ENG-PUDSP21005-R6-GEC.pdf Markup Summary

Subject: Callout
Page Index: 1
Date: 12/14/2022 10:25:55 AM
Author: dsdrice
Color: ■
Layer:
Space:
Page Label: [1] SHT 1 COVER

DESIGNED BY QNA
DRAWN BY QNA
CHECKED BY
H-SCALE AS SHOWN
V-SCALE N/A
JOB NO. 1715.00
DATE ISSUED 11/22/22
SHEET NO. 1 OF 10

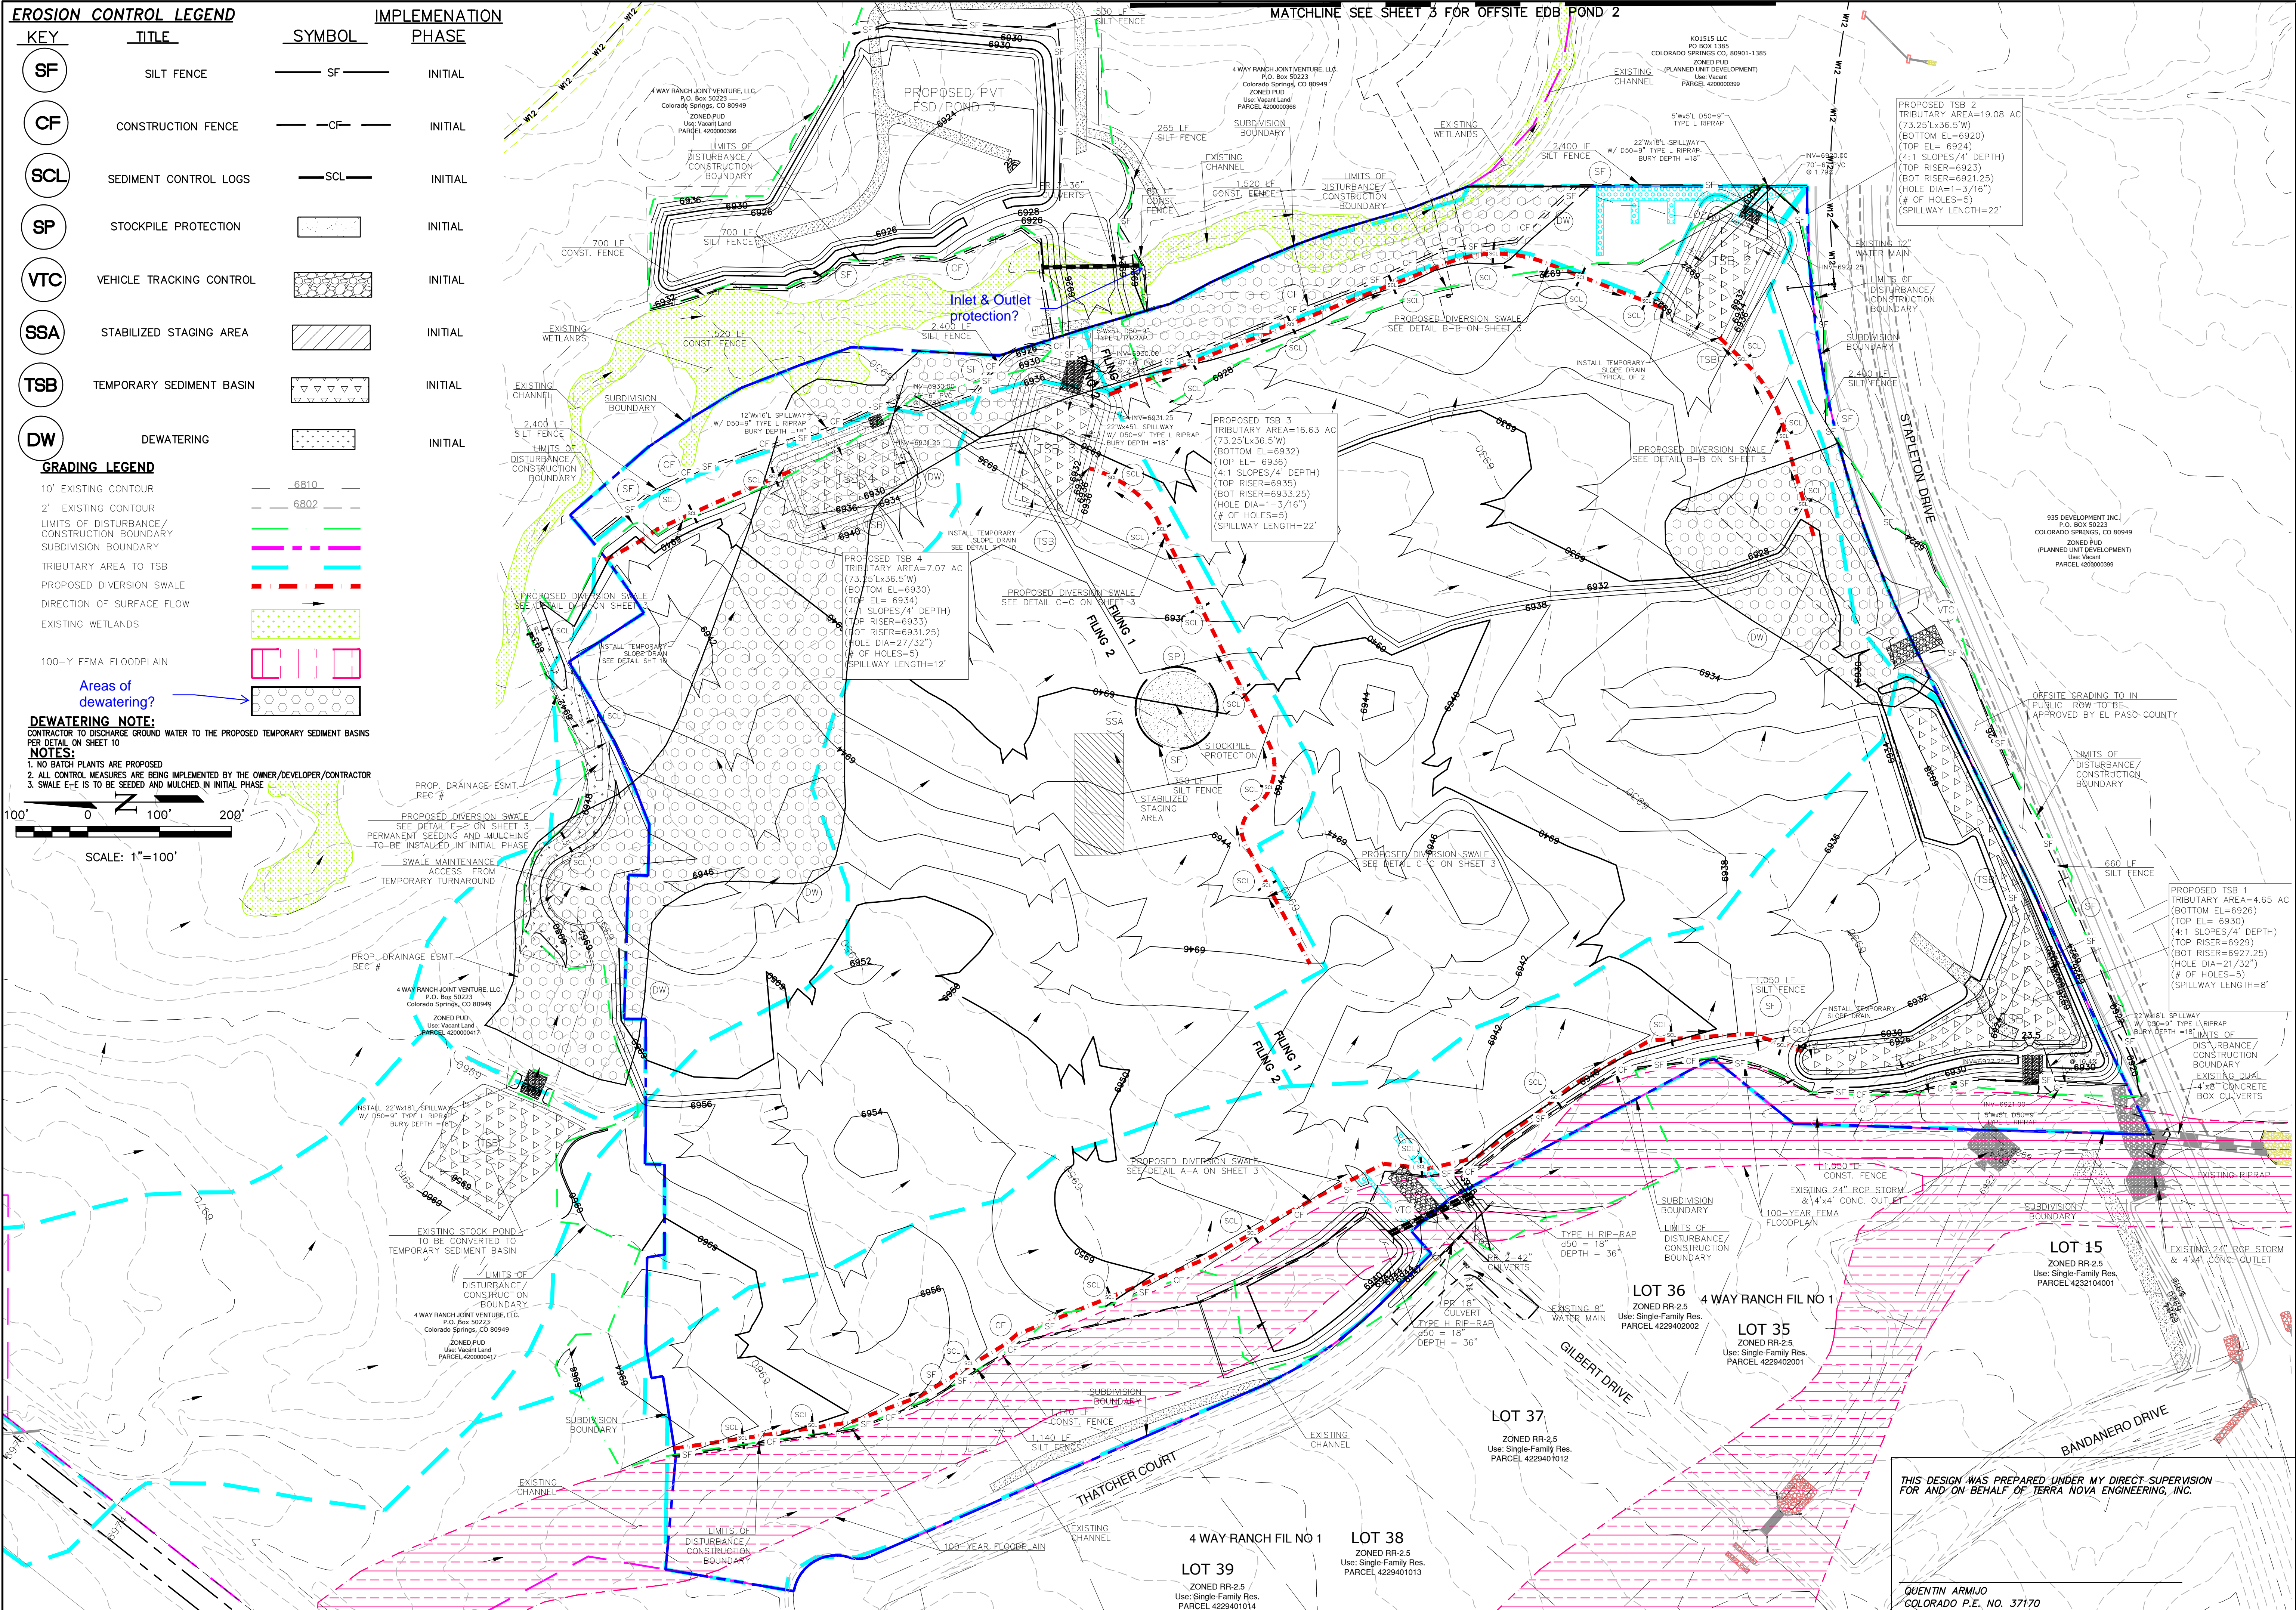
Inlet & Outlet protection?

Areas of dewatering?

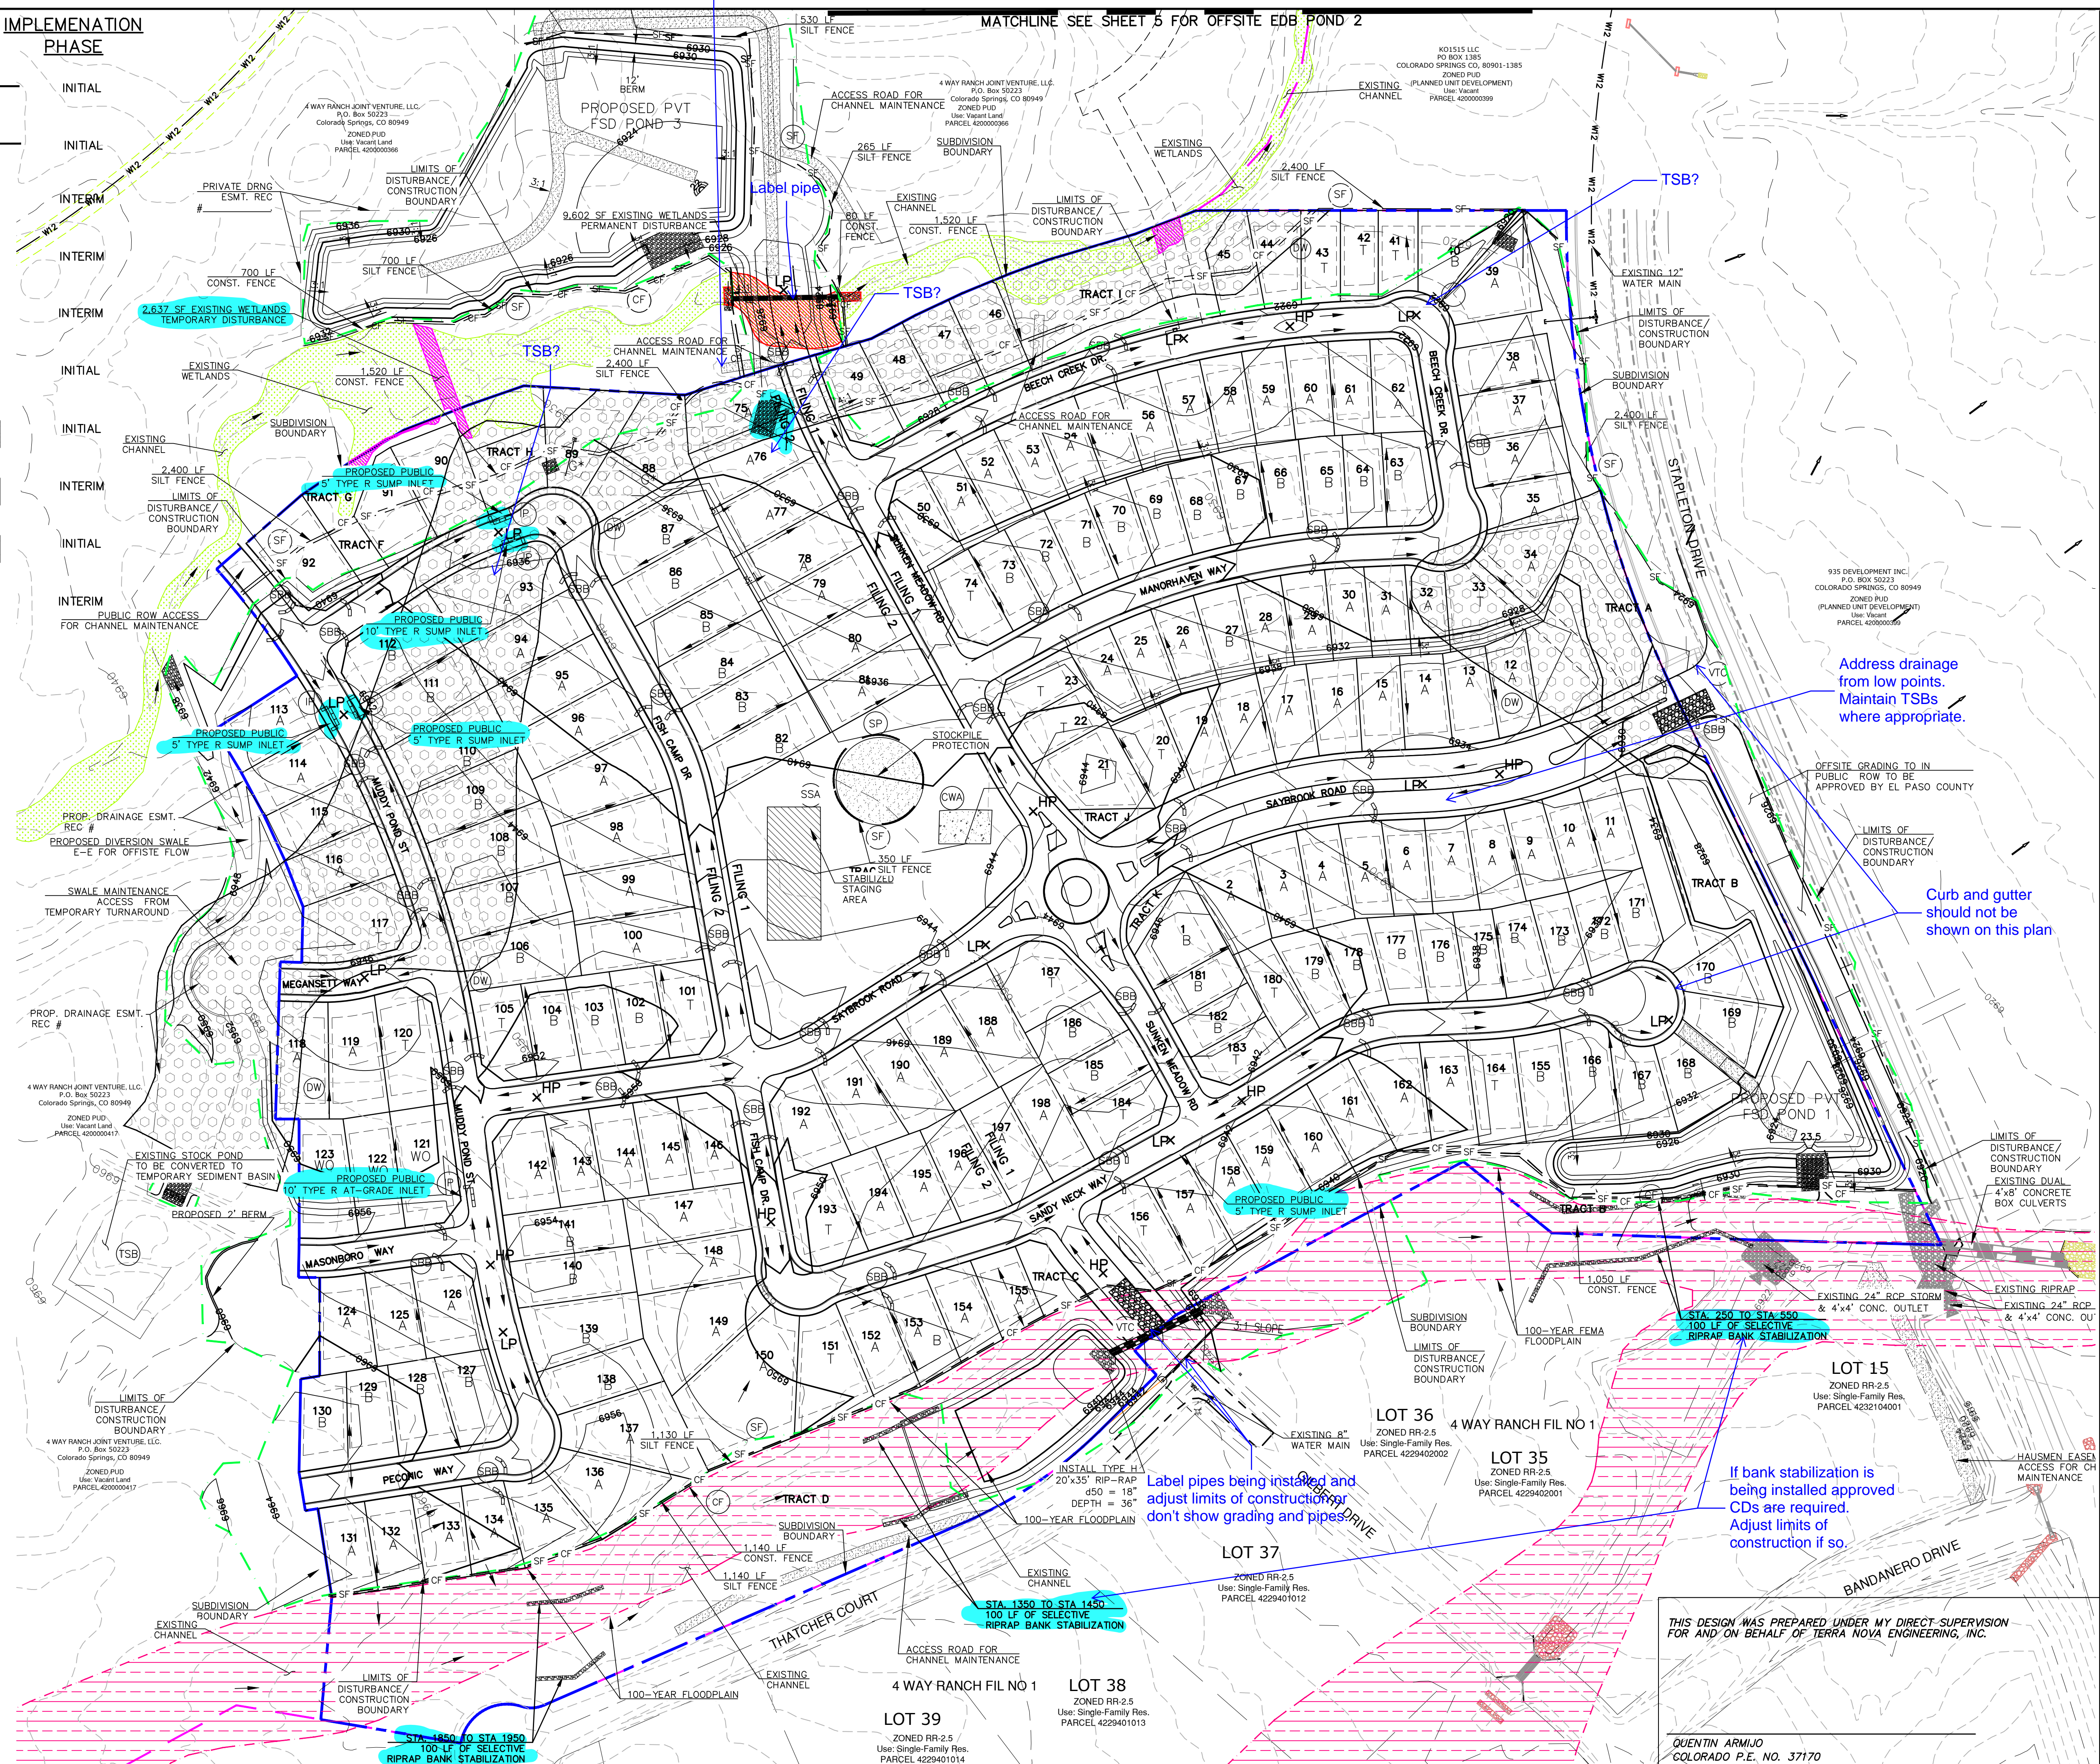
Label pipes being installed and adjust limits of construction or don't show grading and pipes.

TSB?

If bank stabilization is being installed approved CDs are required. Adjust limits of construction if so.

Address drainage from low points. Maintain TSBs where appropriate.

Add TSB

Label pipe

Adjust LOD?

TSB?
